WEST SUSSEX COUNTY COUNCIL CONSULTATION

TO:	Arun District Council FAO: Anita Gardner
FROM:	WSCC - Highways Authority
DATE:	8 September 2021
LOCATION:	Land South Of Littlehampton Road and East of Worthing Road Angmering BN12 6PN
SUBJECT:	A/168/21/PL Erection of 76 No. dwellings, means of access, public open space, play areas, associated infrastructure & landscaping. This application is a Departure from the Development plan, is in CIL Zone 5 and is CIL Liable as new dwellings & affects a Public Right of Way.
DATE OF SITE VISIT:	n/a
RECOMMENDATION:	More Information
S106 CONTRIBUTION TOTAL:	n/a

Detailed Layout

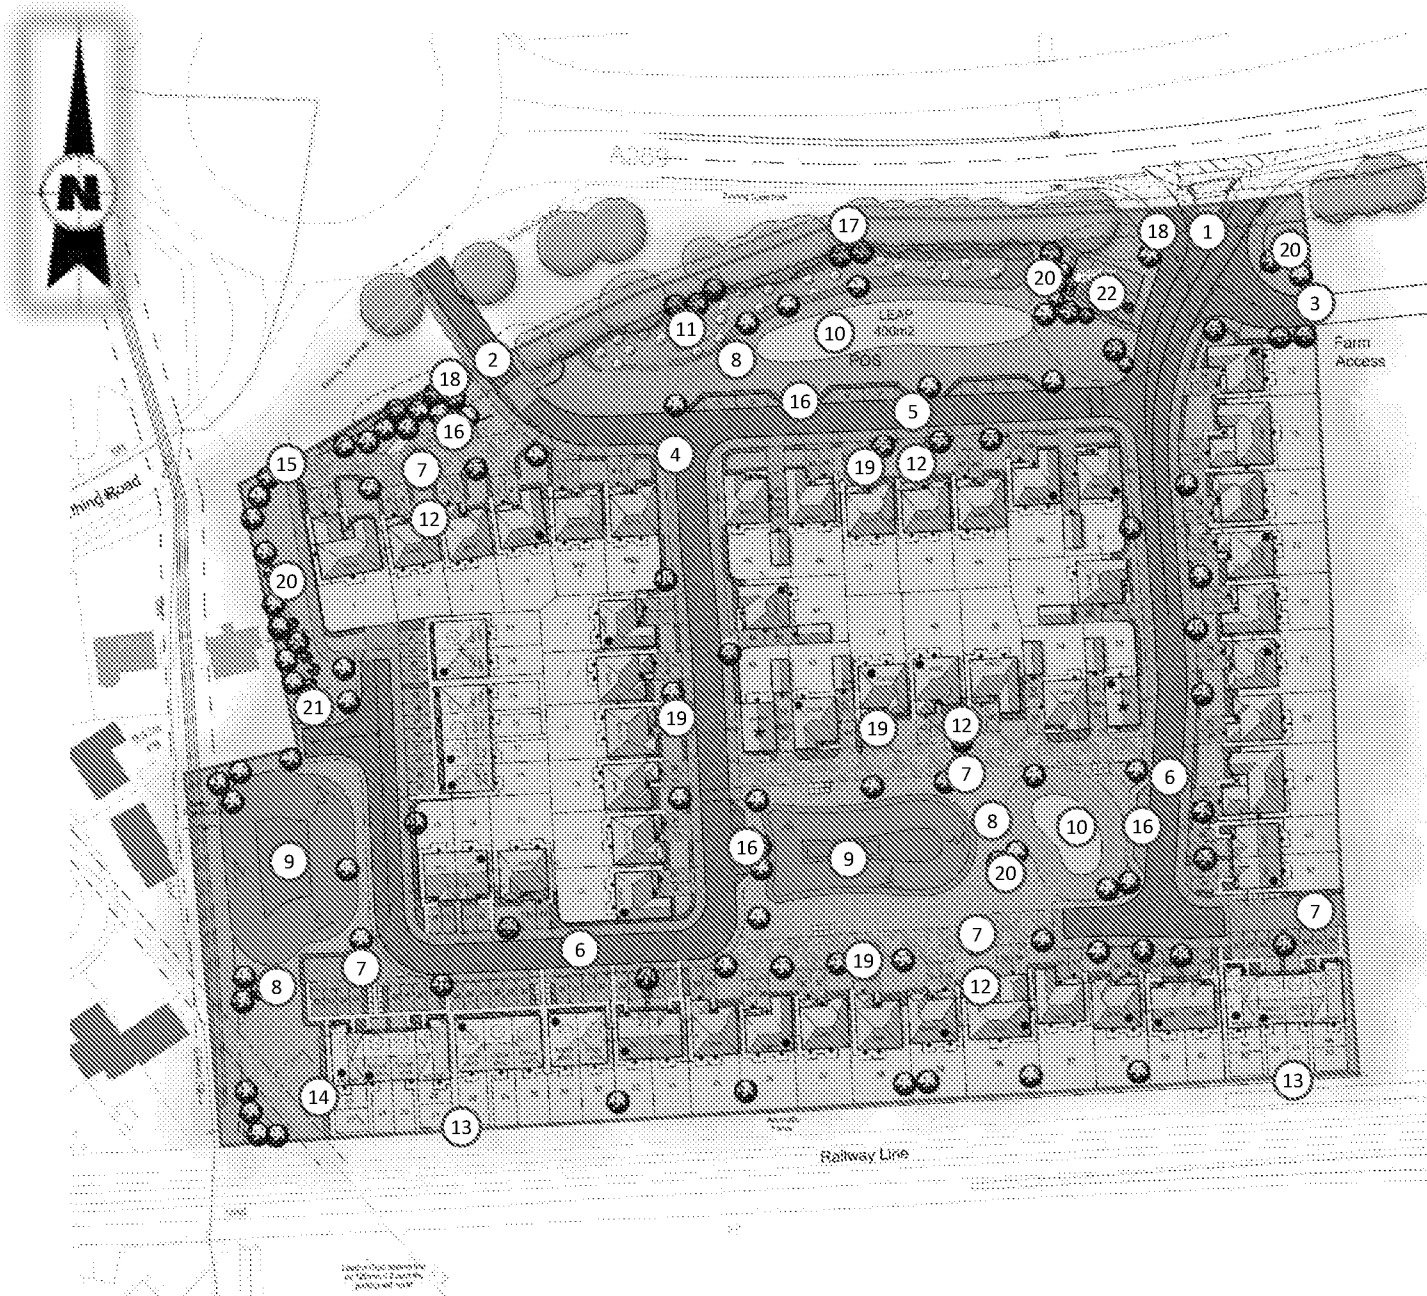
with the layout as indicated although and with respects to the retained access onto the A259 Roundstone By-Pass Roundabout, the layout could have been better designed so to discourage movements from the development onto the roundabout; the inclusion of the kerb tightening within the layout is noted but more could have done with the design of the roads.
